CITY OF PORTLAND

BUILDING PERMIT

Located At 84 LINCOLN ST

has permission for interior renovations with an exterior deck (Two Family Dwelling).

LOWER LEVEL RENOVATION
PLAN

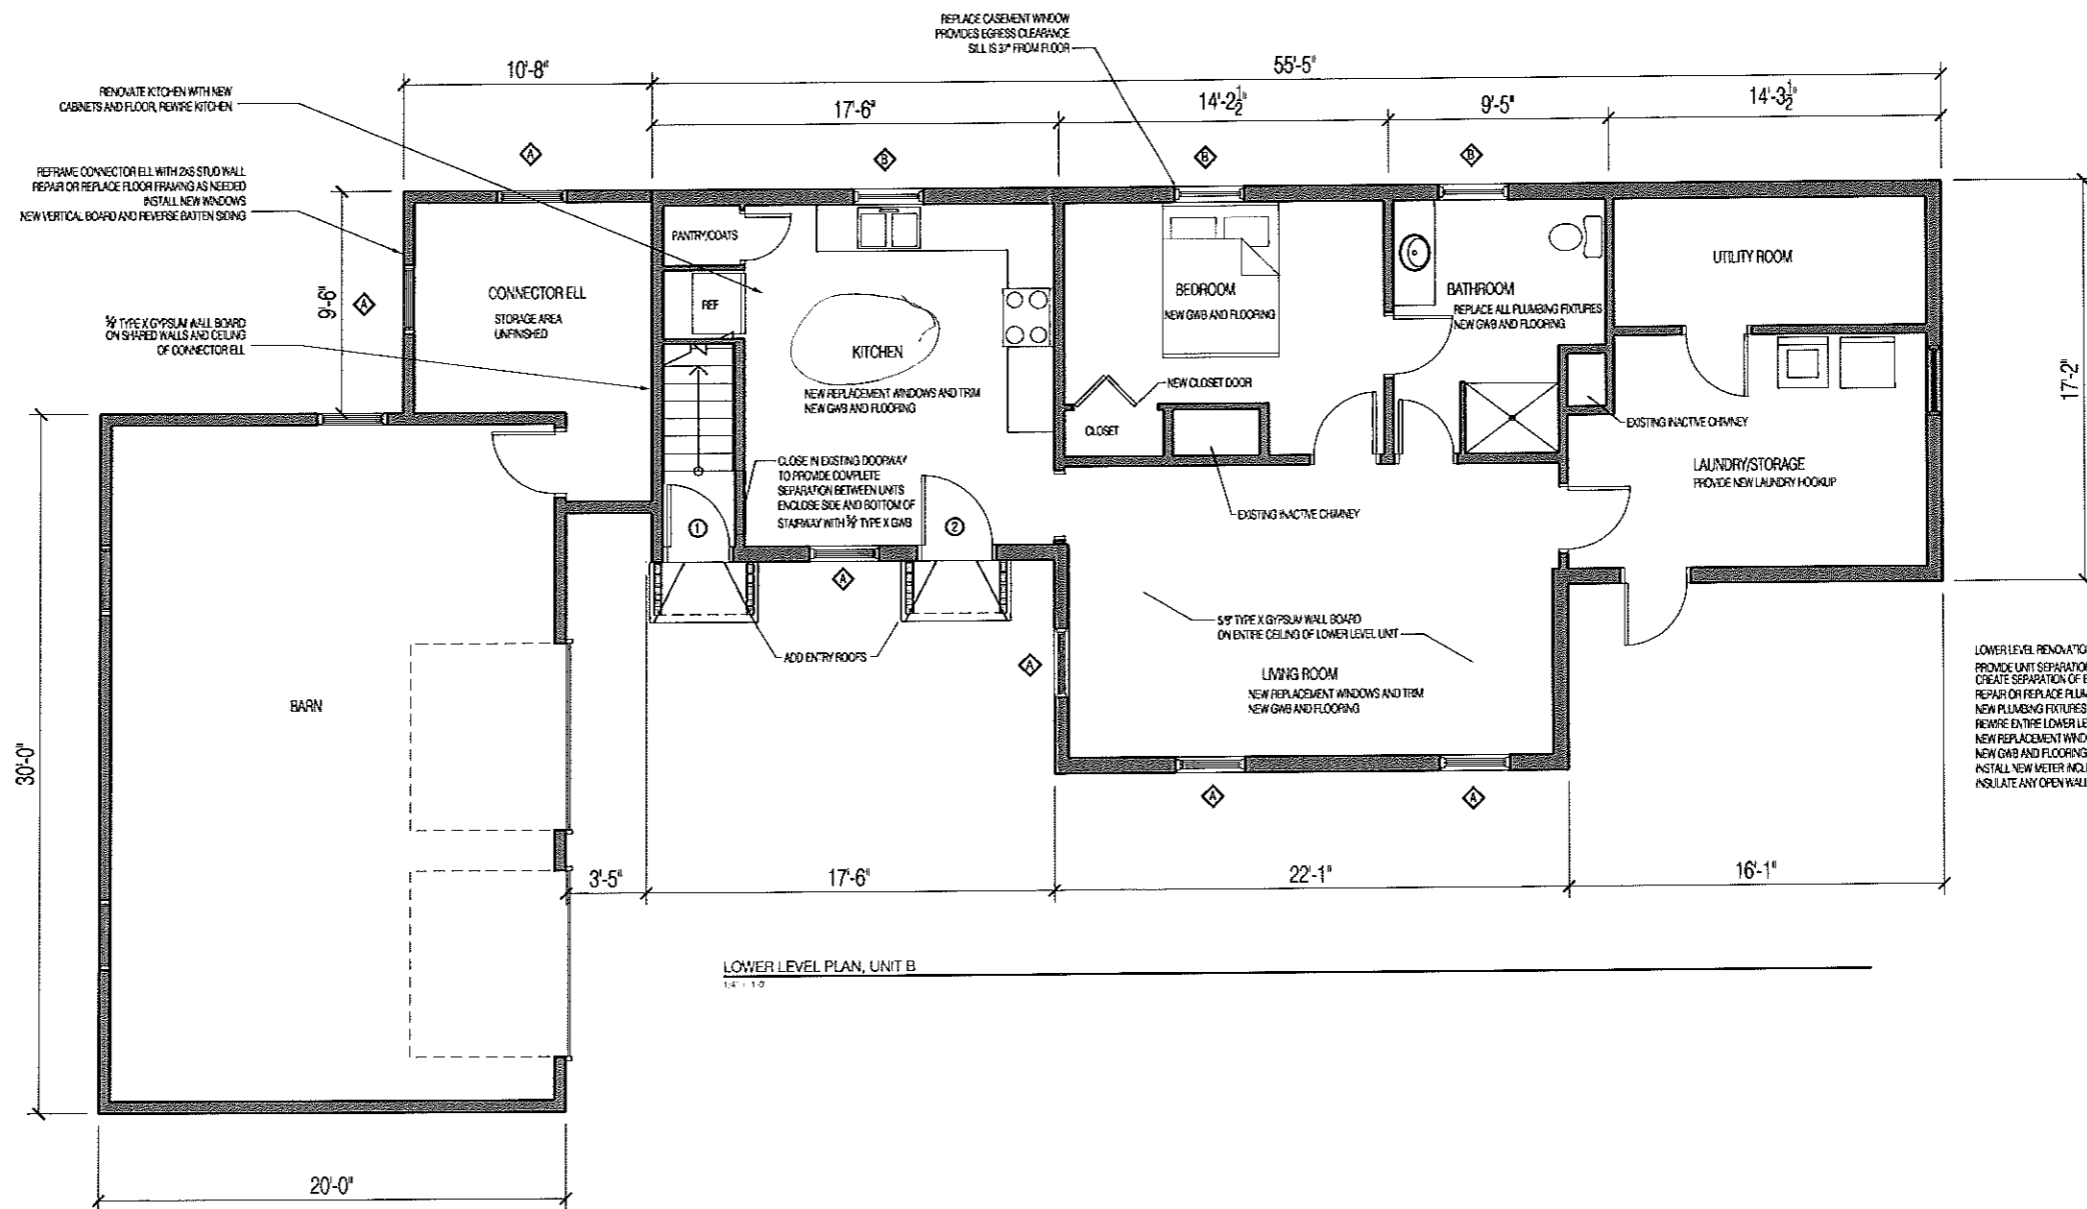
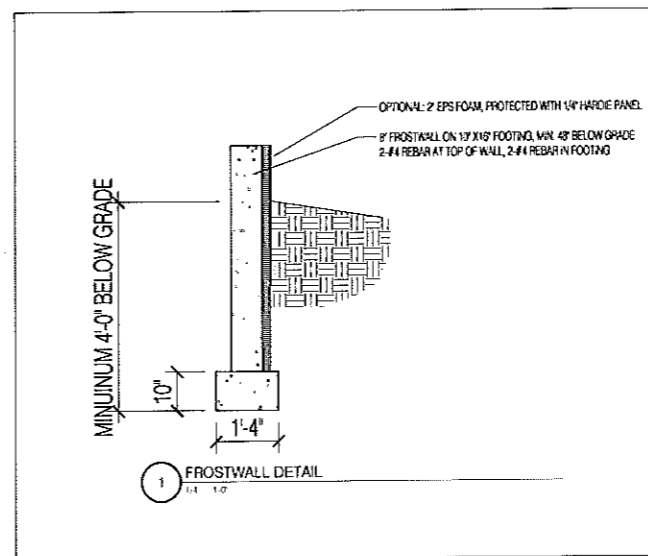
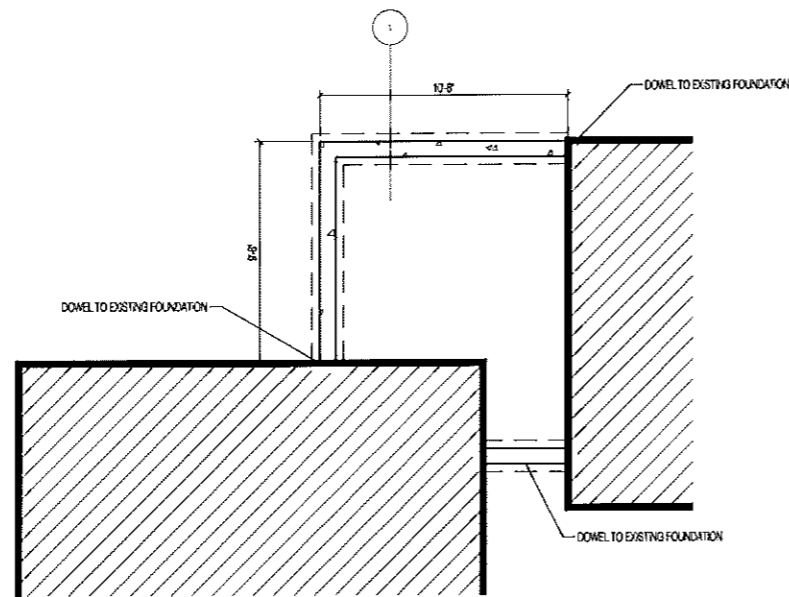
5. Designer stated that a code compliant emergency escape will be provided in "Unit B's" bedroom. Window sills in locations more than 72 inches from finished grade shall be a minimum of 24 inches (no higher than 44 inches) above the finished floor of the room, or in compliance with Section R612.4.2 Operation for emergency escape.
6. Safety Glazing will comply with Section R308 in all hazard areas, see attached documentation.
7. (R311.5.1) An Attachment to resist both vertical and lateral forces will be provided on the exterior deck.

DECK ELEVATION AND SECTION

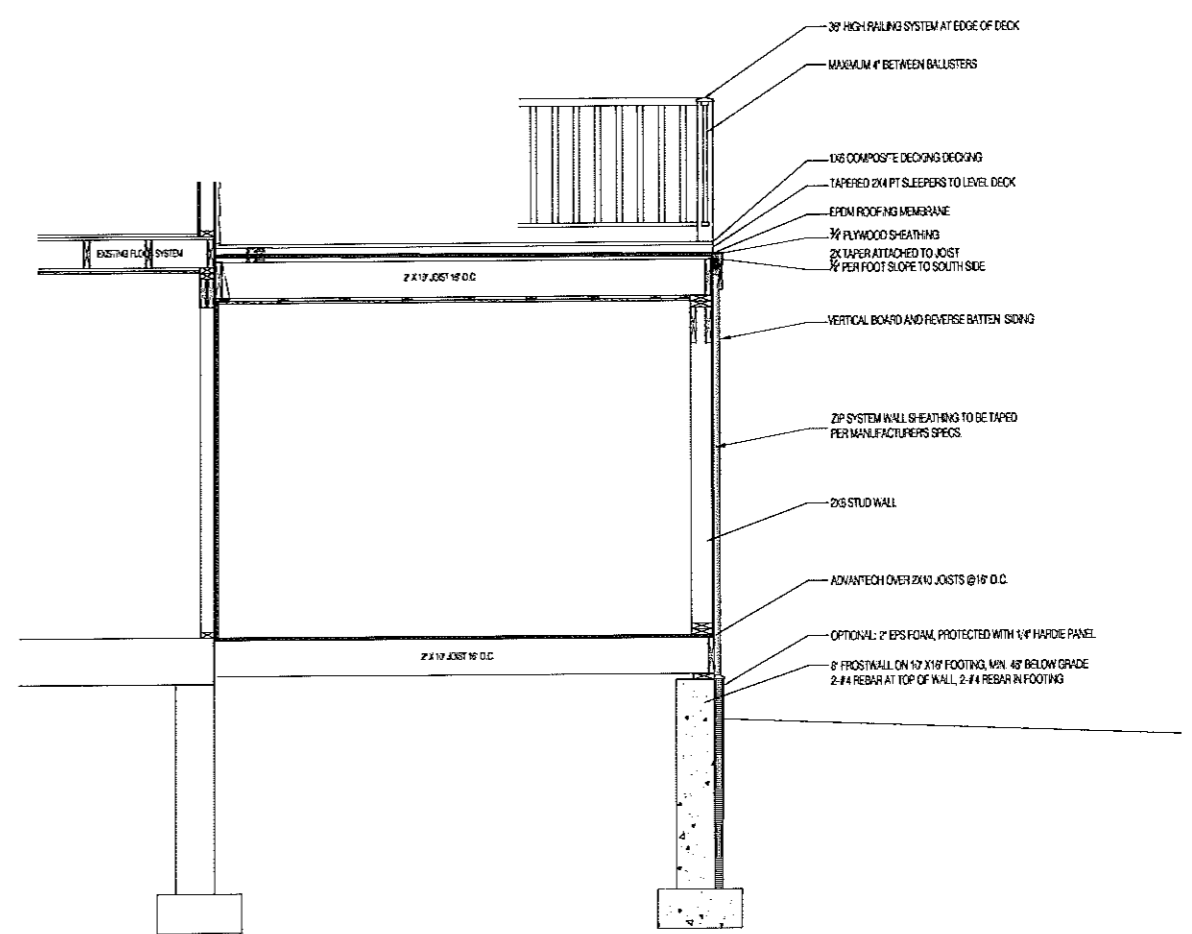
8. Insulation shall comply with the IECC, 2009 (Maine State Energy Codes).
9. R302.4 Dwelling unit rated penetrations. Penetrations of wall or floor/ceiling assemblies required to be fire-resistance rated in accordance with Section R302.2 or R302.3 shall be protected in accordance with this section.
10. **Note: Spoke with the Designer and memorialized compliance with Section R302.6 Dwelling/garage fire separation and Table R302.1, see below. The renovated stairs/ egresses will comply with sections R311 through R312.**
